**Nationally Significant Infrastructure Project: EN010149
Springwell Solar farm**

**Response to The Examining Authority's written questions and requests for
information (ExQ2) issued on 2 September 2025**

Prepared by Lincolnshire County Council (LCC)

September 2025

DOCUMENT: Outline Written Scheme
of Investigation
TITLE: Figure 2 - Currently known
archaeological baseline
PINS REFERENCE:

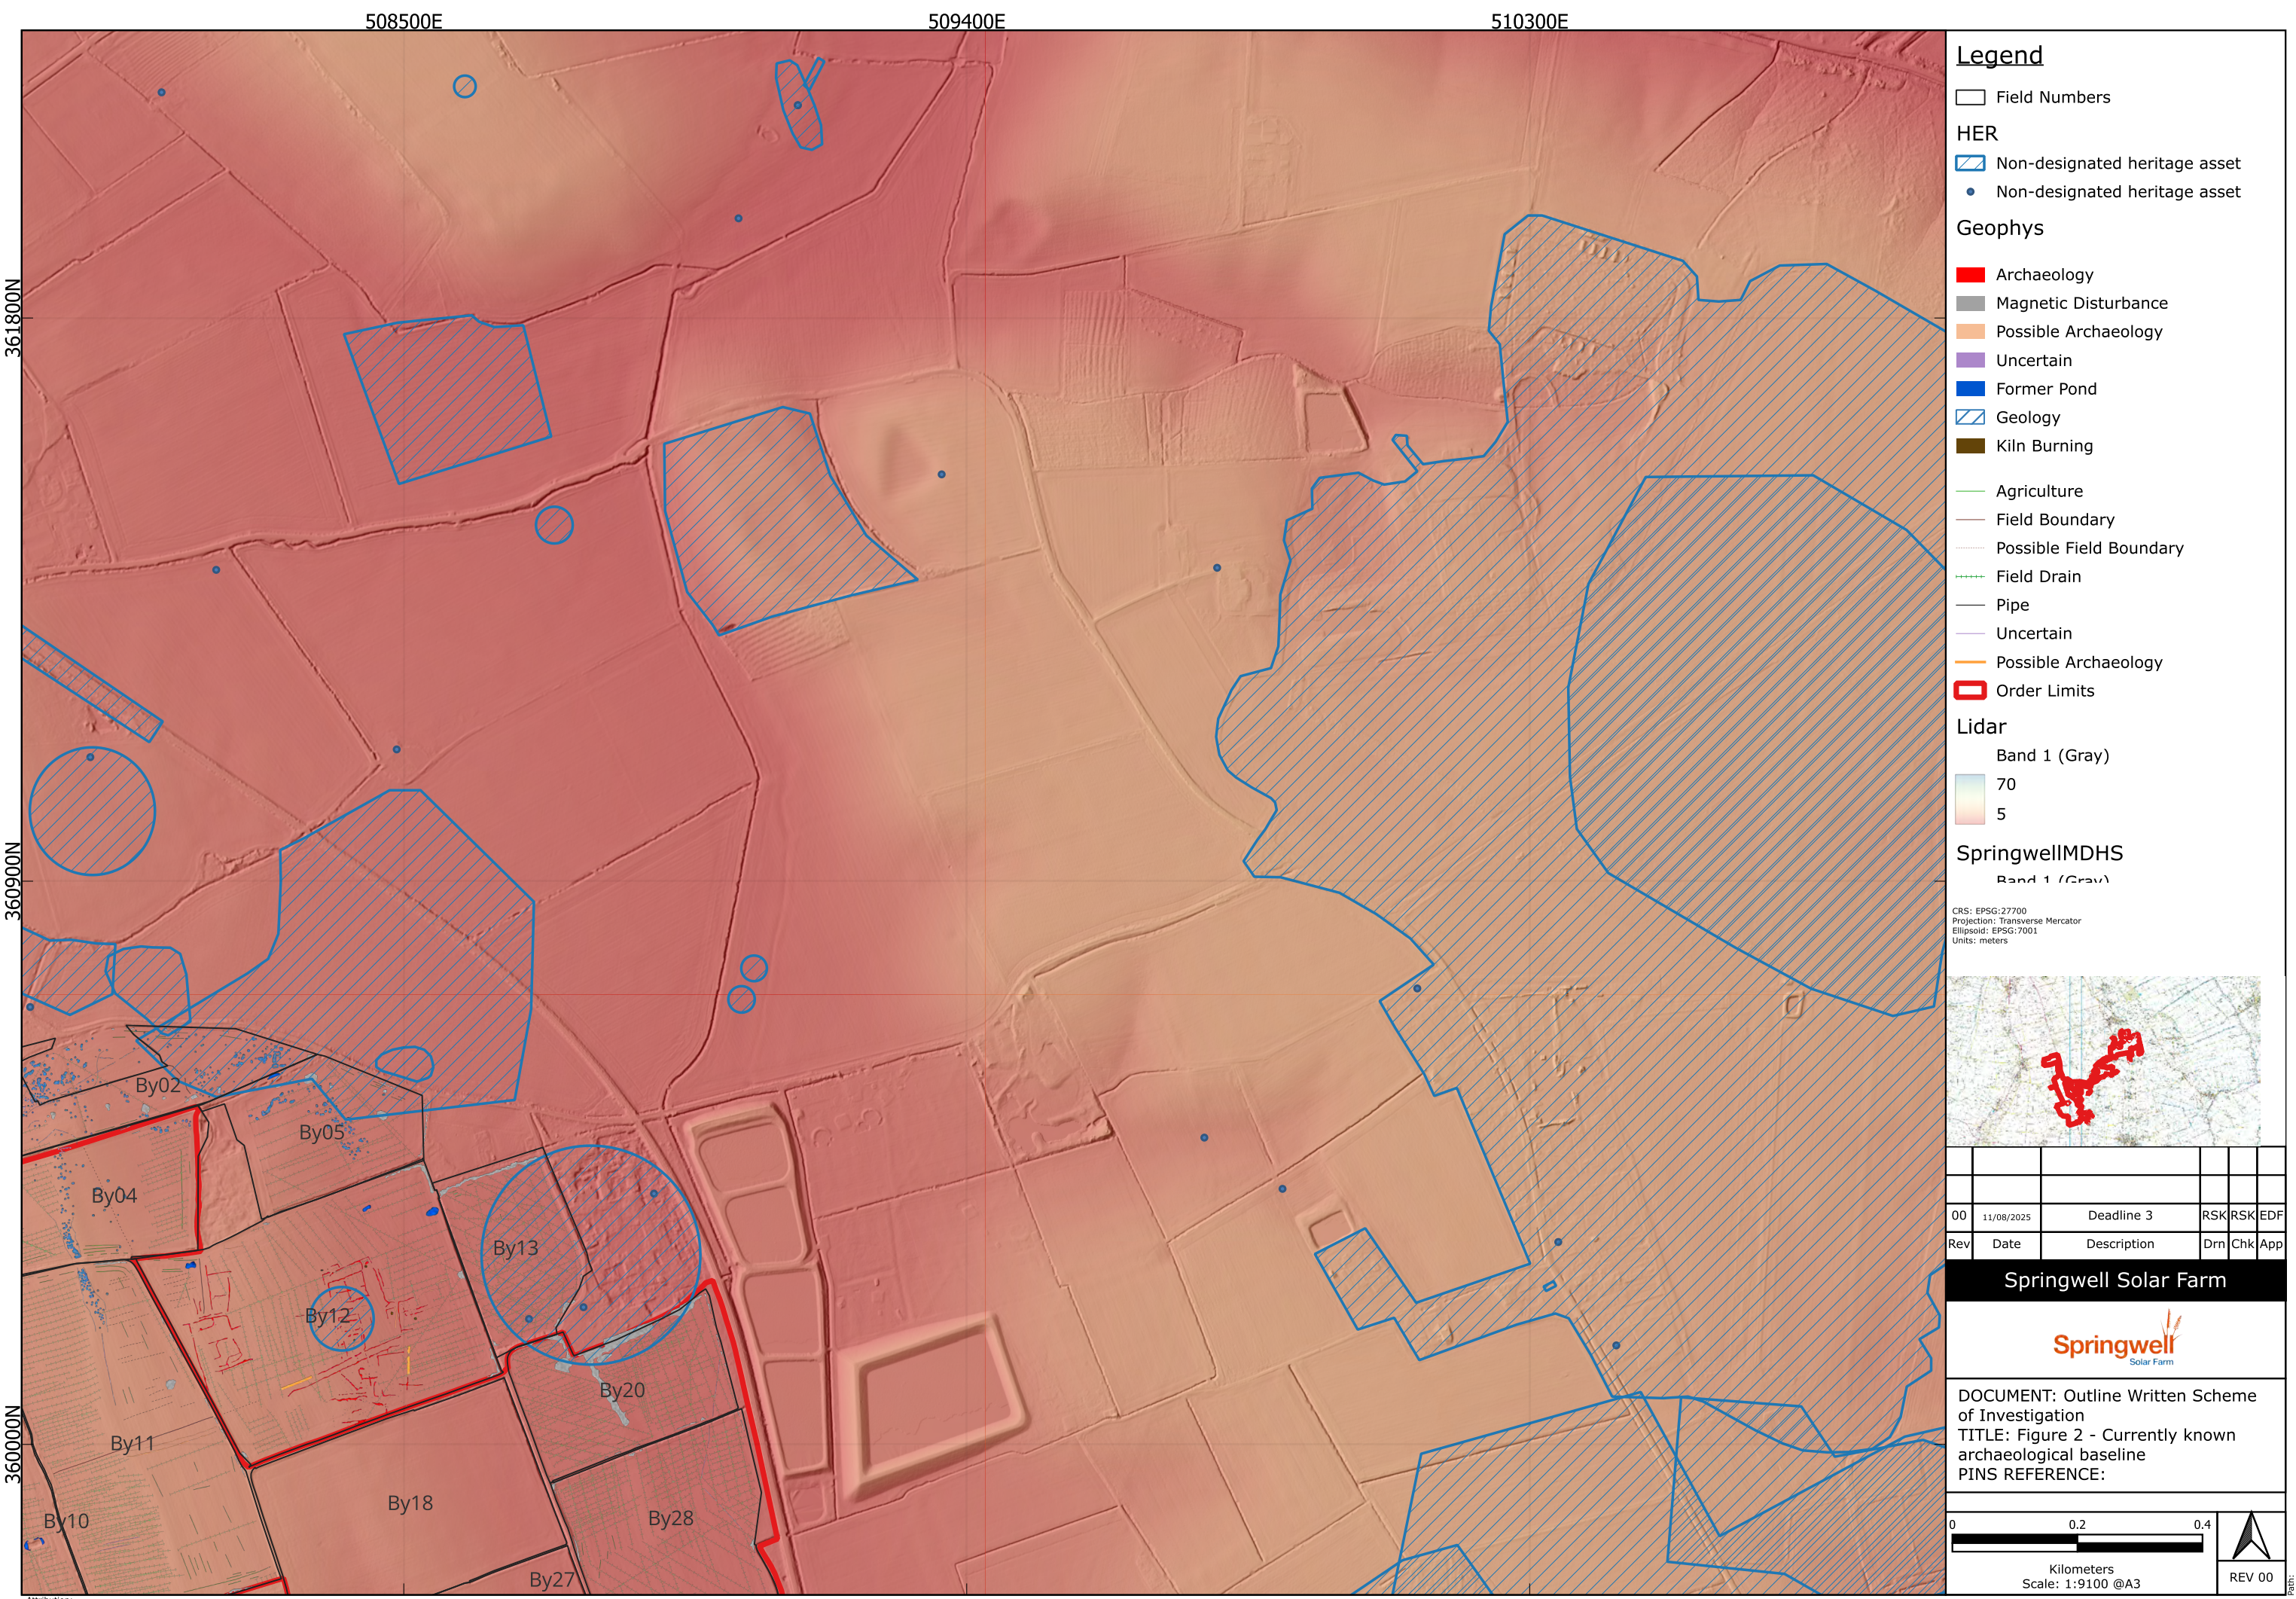
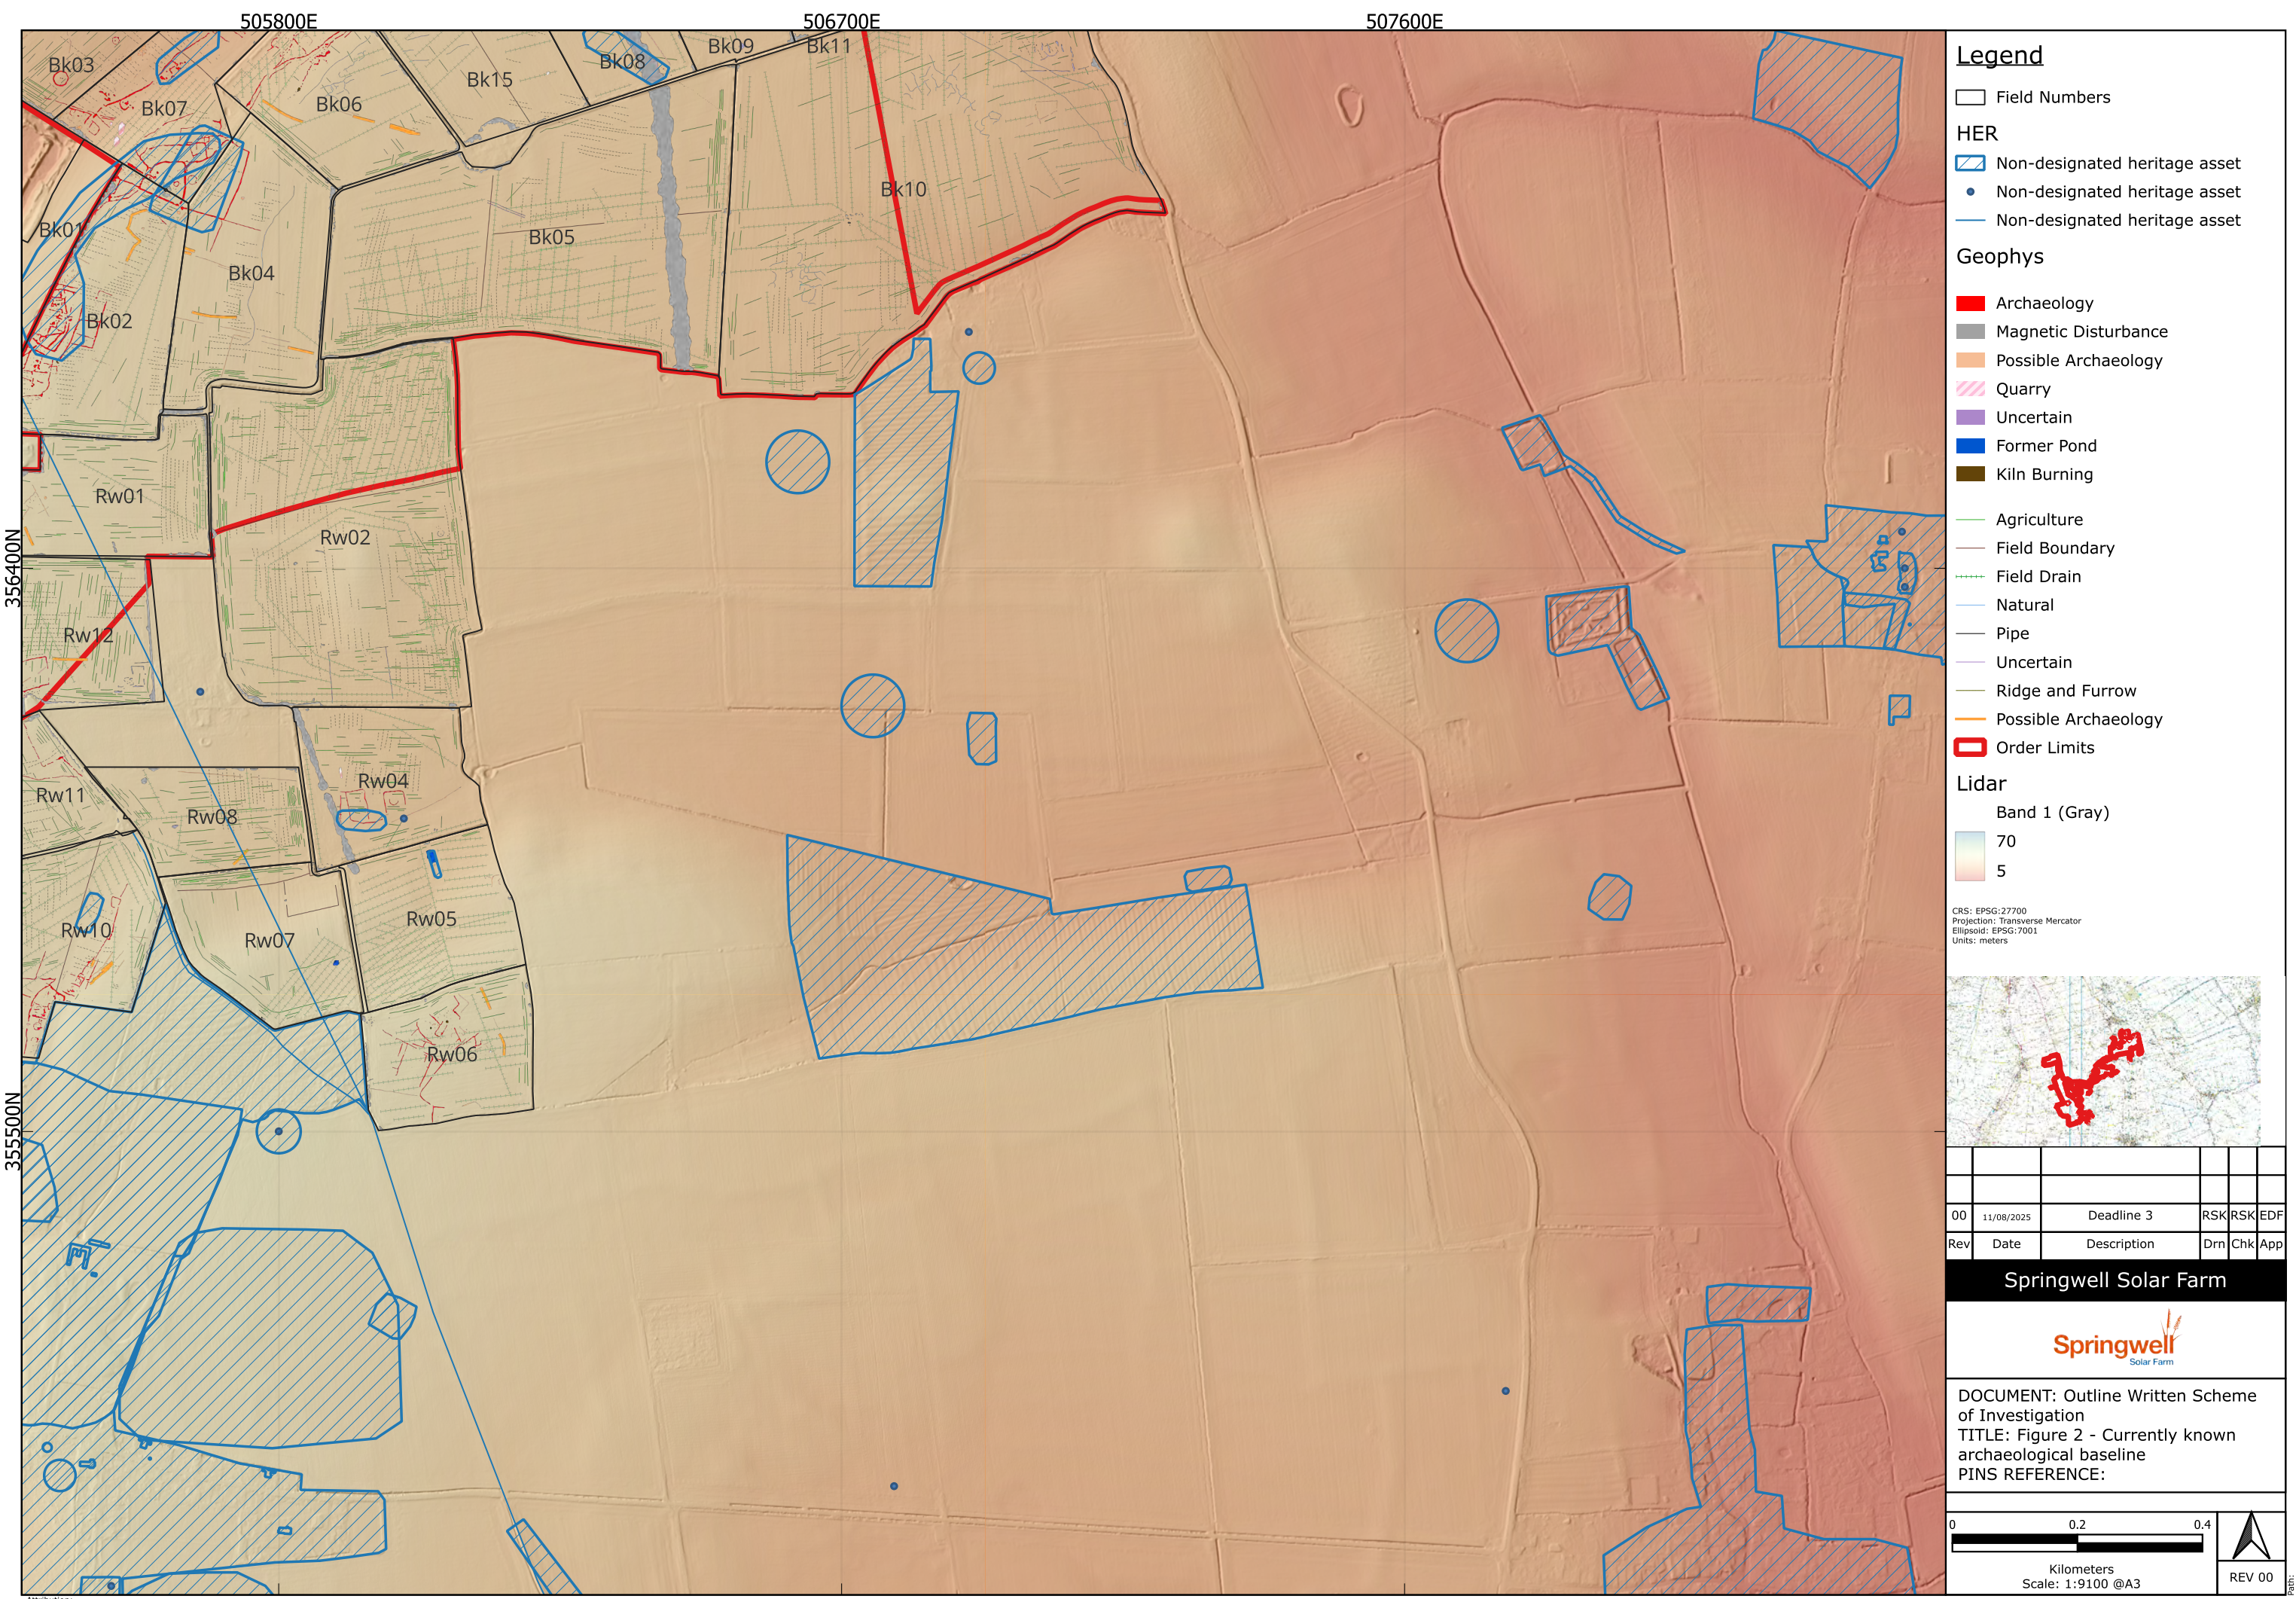
7.	Cultural Heritage	
Q2.7.3	<p>Archaeological Desk Based Assessment and outline Written Scheme of Investigation</p> <p>The Applicant has produced an updated ADBA and an updated Outline Written Scheme of Investigation (oWSI). LCC and HE are asked to:</p> <ol style="list-style-type: none"> Identify any outstanding concerns. Advise if it is acceptable for these matters to be resolved in detailed design stage; and Advise whether you consider that the oWSI provides satisfaction that these matters will be addressed post-consent. 	<p>The Applicant, LCC and Historic England are undertaking regular meetings to resolve any limitations in the existing oWSI and ensure that the document is fit for purpose.</p> <p>LCC is pleased to note that the oWSI has seen revision following meetings and feedback provided by Historic England and ourselves. As agreed with the Applicant and Historic England, the approach will be based on evaluating the areas of impact once these have been identified at detailed design stage, with a question-led approach contributing to the formulation of the mitigation strategy once the presence, significance and impact is understood from the evaluation results. The main point of debate is the</p>

ExQ2	Question	LCC Response
		<p>location of the remaining evaluation trenches, which will not be known until detailed design is complete. We are pleased to see that an Archaeological Clerk of Works has been included within the proposed archaeological management strategy.</p> <p>Blanket trenching is not being considered.</p> <p>LCC is confident that these matters of debate yet to be agreed can be appropriately dealt with at detailed design stage, as the trenching requirements cannot be developed until we have the detailed design information.</p> <p>The oWSI contains appropriate provision for Task Specific Written Schemes of Investigation and Location Specific Written Schemes of Investigation to be produced as part of the archaeological works that the Applicant has committed to. These documents would need approval by LCC prior to any works being undertaken and thus we have confidence that there will be sufficient and appropriate programme of archaeological evaluation undertaken to inform the archaeological mitigation and management strategy.</p>
